**KIRKLEES METROPOLITAN COUNCIL  
INVESTMENT & REGENERATION SERVICE**

Reference No:	<b>2024/62/90160/W</b>
Site Address:	Ashfield Hotel, 95, New North Road, Huddersfield, HD1 5ND
Description:	Erection of single storey quarter house (Listed Building within a Conservation Area)
Recommending Officer:	Laura Yeadon

**DECISION - REFUSE**

## **Officer Report**

SITE PLAN (SCALE 1:500)

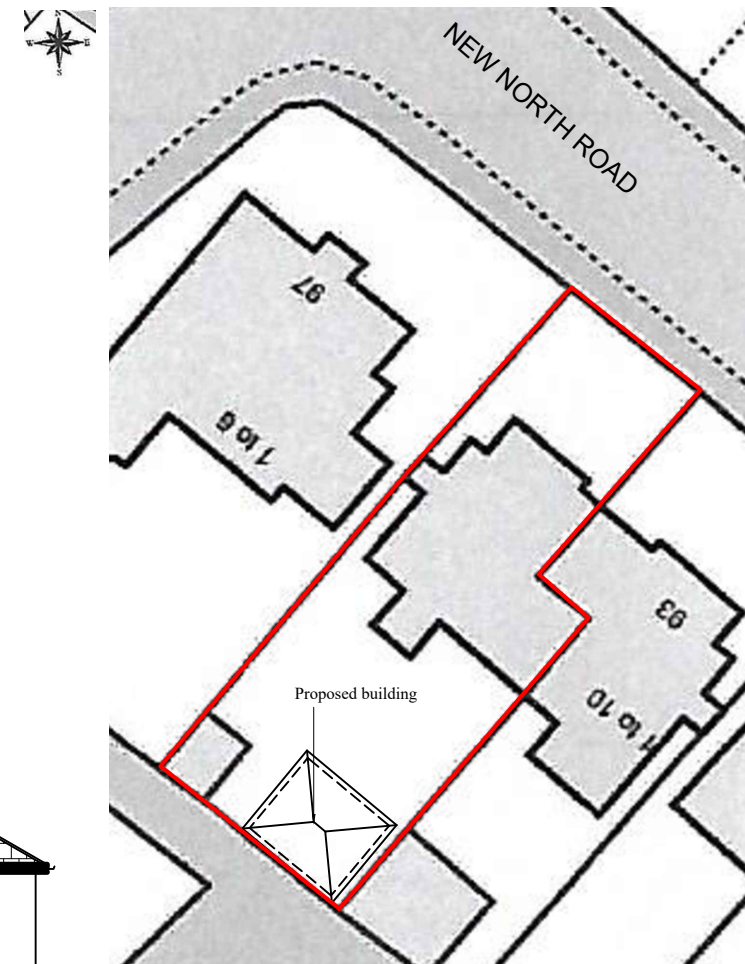
The application is for the erection of a single storey quarter house which would be used in conjunction with the operation of the hotel and would provide facilities for the night shift employees in the form of a bedroom, bathroom, lounge and dining/kitchen. The building would be located within the rear garden of the property, adjacent to an existing shed.

The comments go on to state that whilst the building is simple in design and constructed from matching materials, there are concerns regarding the principle of the development which would cause less than substantial harm to the setting of the listed building by the construction of another building within a relatively small garden area.

Therefore, Conservation and Design Officers do not consider that the construction of a building within the rear garden has been clearly justified and would recommend that the provision of suitable accommodation within the existing building is explored, which in turn would ensure that staff are within the main building and more readily available for guests.

1. The proposed building is considered to cause less than substantial harm to the setting of the host listed building by the construction of another building within its curtilage. Paragraph 208 of the National Planning Policy Framework considers that great weight should be given in terms of the public benefit of development against the harm to the heritage asset from the proposed development. Public benefits have not been demonstrated that would outweigh the harm caused in this case. The development would therefore be contrary to the Council's duties under the Planning (Listed Buildings and Conservation Areas) Act 1990, Policy LP35 of the Kirklees Local Plan and policies within the National Planning Policy Framework.
